CITY OF ALBUQUERQUE

**Re: Unser Blvd & Bluewater Road Development
Tracts L-1-C-1 & L-1-C-2 Atrisco Business Park,
Grading and Drainage Plan (Resubmittal)
Engineer's Stamp dated ~~11-05-08~~ (K-10/D023C1)
12-29-08**

RE: Grading and Drainage Plan K-10/D023C1

GRADING PLAN

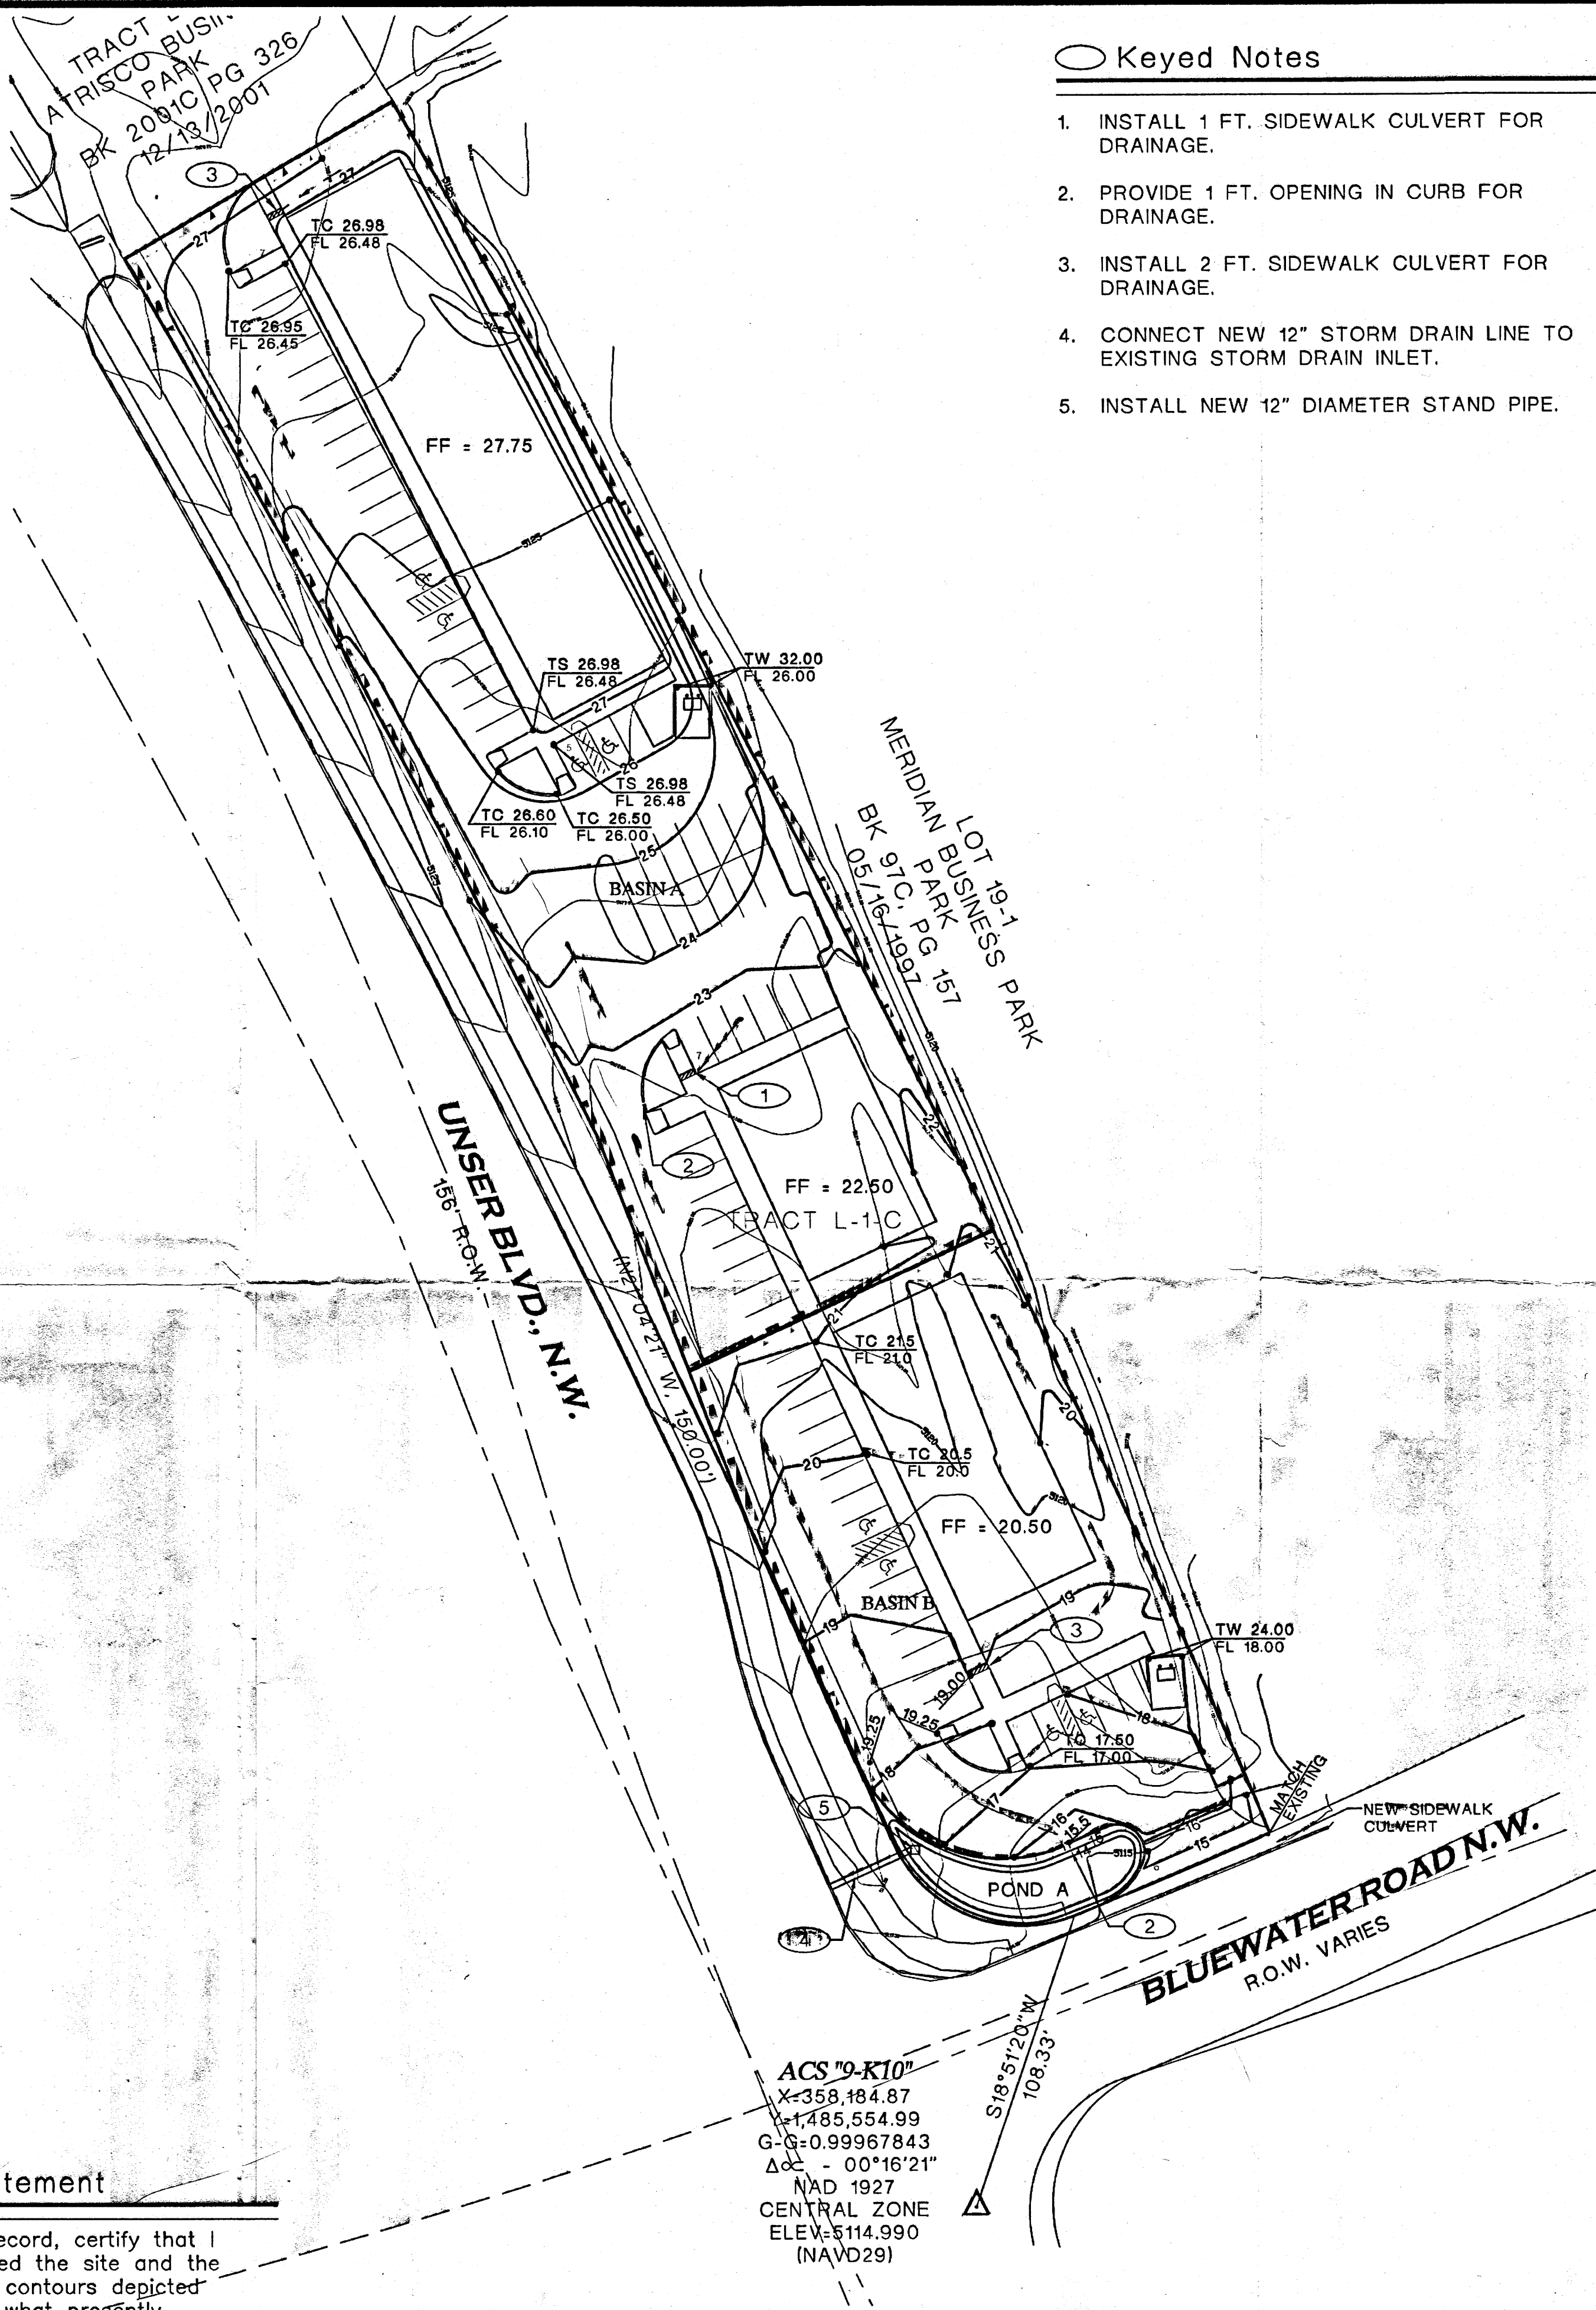
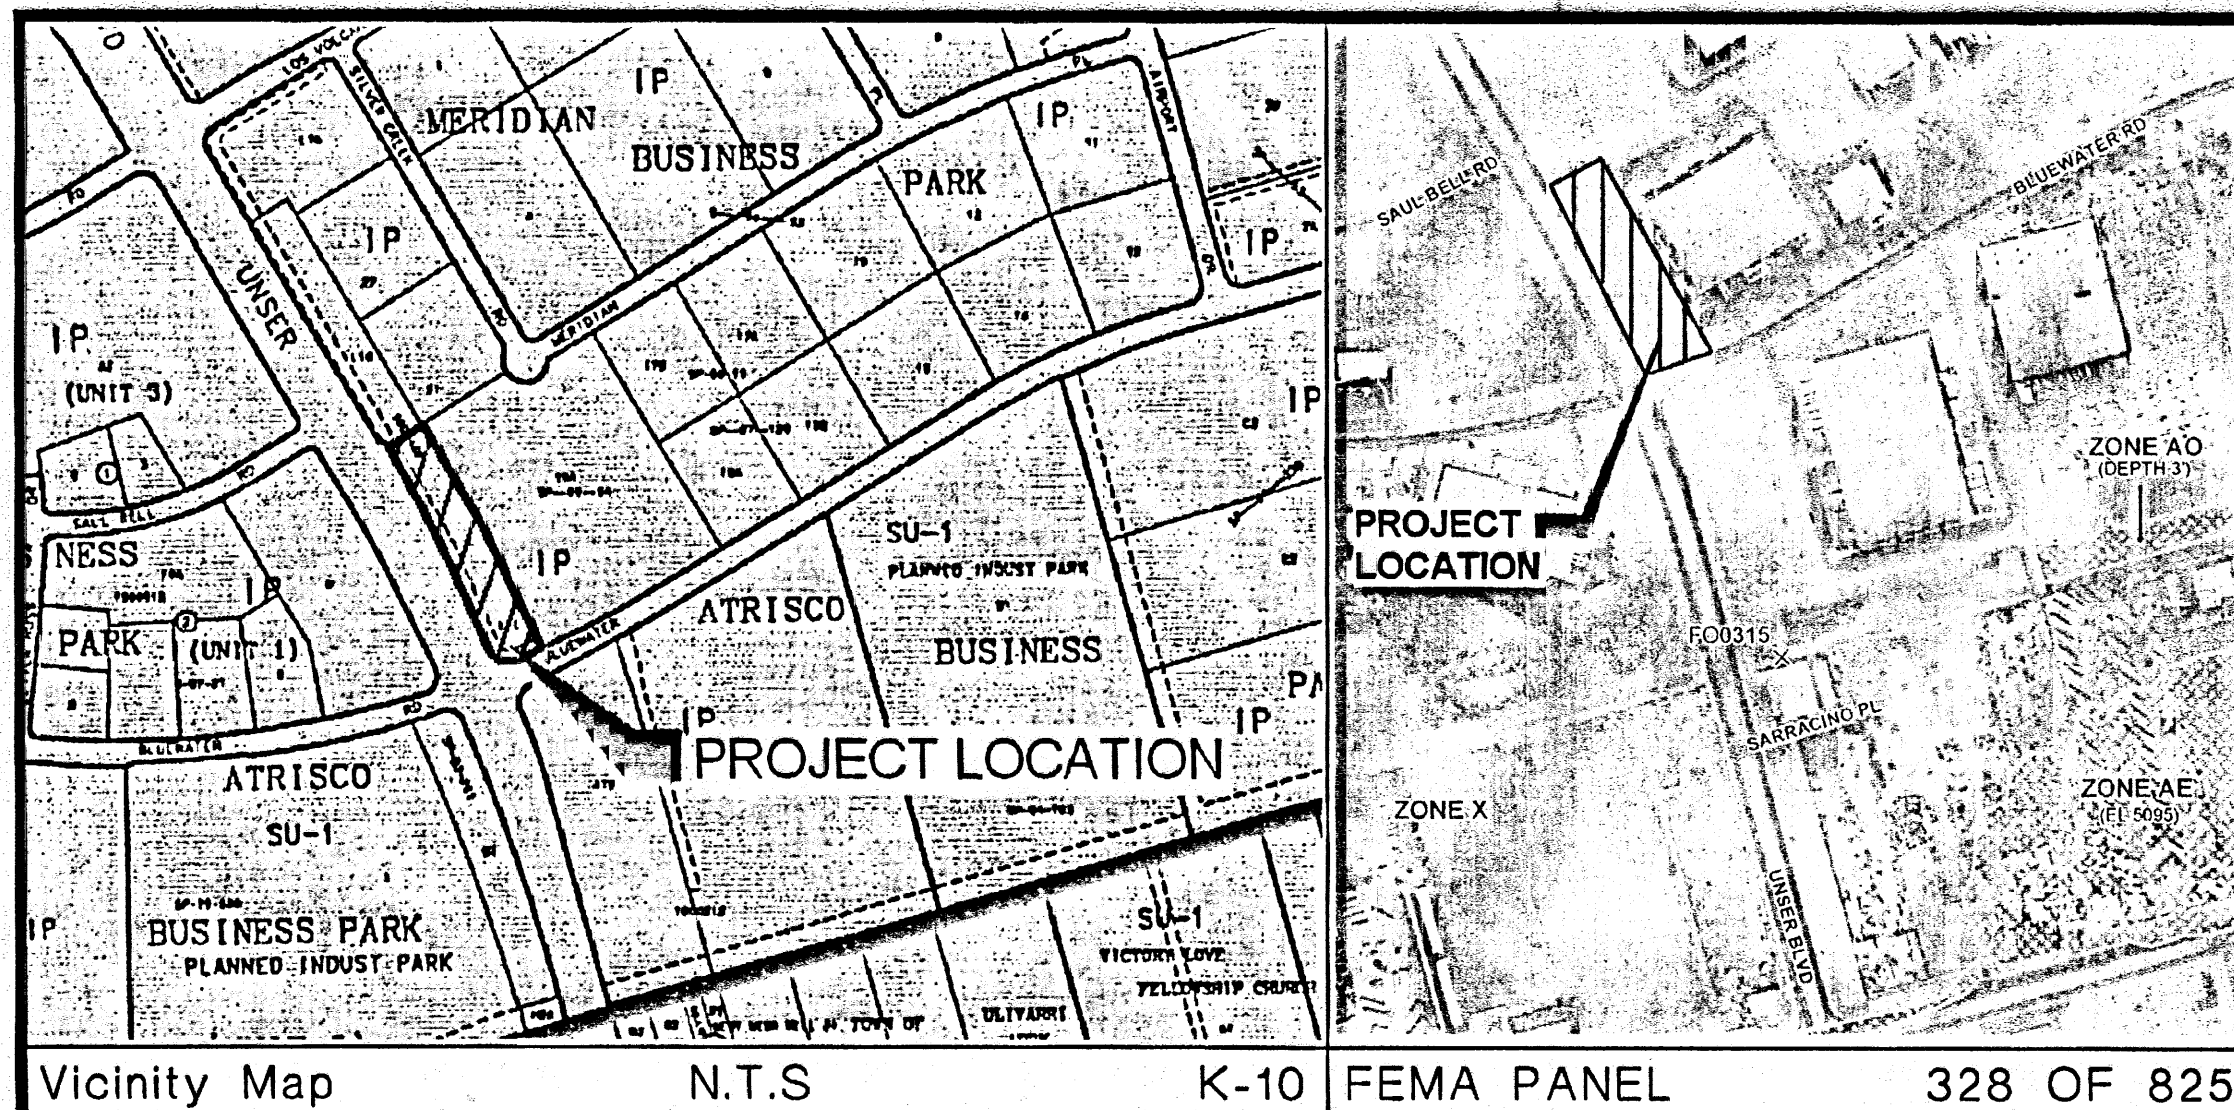
2. Provide spot elevations at the trash enclosure to assure positive flow.
The spot elevations have been added.
3. Show water block at Bluewater as stated on the drainage narrative.
The water block has been added.

4. FEMA Panel number will be needed for the 100-year floodplain.
The FEMA Panel has been added.
5. Information for the proposed new sidewalk culvert on Bluewater will need to be provided.
The sidewalk culvert was removed from the plan since it will now drain into Unser.

6. Invert elevations, and details for the 12 inch standpipe and connection will be needed.
Additional information regarding the invert elevations was added. In addition, the standpipe was replaced with a 2 ft. by 2 ft. area inlet. The connection is as per COA standards, as called out on the plan.

8. Will a cross lot drainage easement be needed with adjacent property to the North? Explain.

1. Please quantify all offsite flows entering site from the North and East.
2. Provide spot elevations at the Trash Enclosure to assure positive flow.
3. Show water block at Bluewater as stated on Drainage Narrative.
4. FEMA Panel number will be needed for the 100-year floodplain.
5. Information for the proposed new sidewalk culvert on Bluewater will to be provided.
6. Invert elevations, and details for the 12" stand pipe and connection will be needed.
7. Pipe calculations will be needed to substantiate that the pond will drain at the rate equivalent to the Historic runoff rate
8. Will a cross lot drainage easement be needed with adjacent property to the North? Explain?

1. Please quantify all flows entering the site from the North and East.
The area to the North and East are part of other drainage basins that drain away from this site, and thus do not contribute any flows to this site.

7. Pipe calculations will be needed to substantiate that the pond will drain at the rate equivalent to the Historic runoff rate.
The ahymo input, output and pond excel files have been included with this submittal. The discharge will be higher than the historic rate, but as per

conversation with Brad Bingham, are acceptable due to the fact that the storm drain in Unser has adequate capacity to accept the runoff from this site.

A cross lot drainage easement is not required since the area to the north is part of a separate drainage basin that drains to the northeast off of this site.
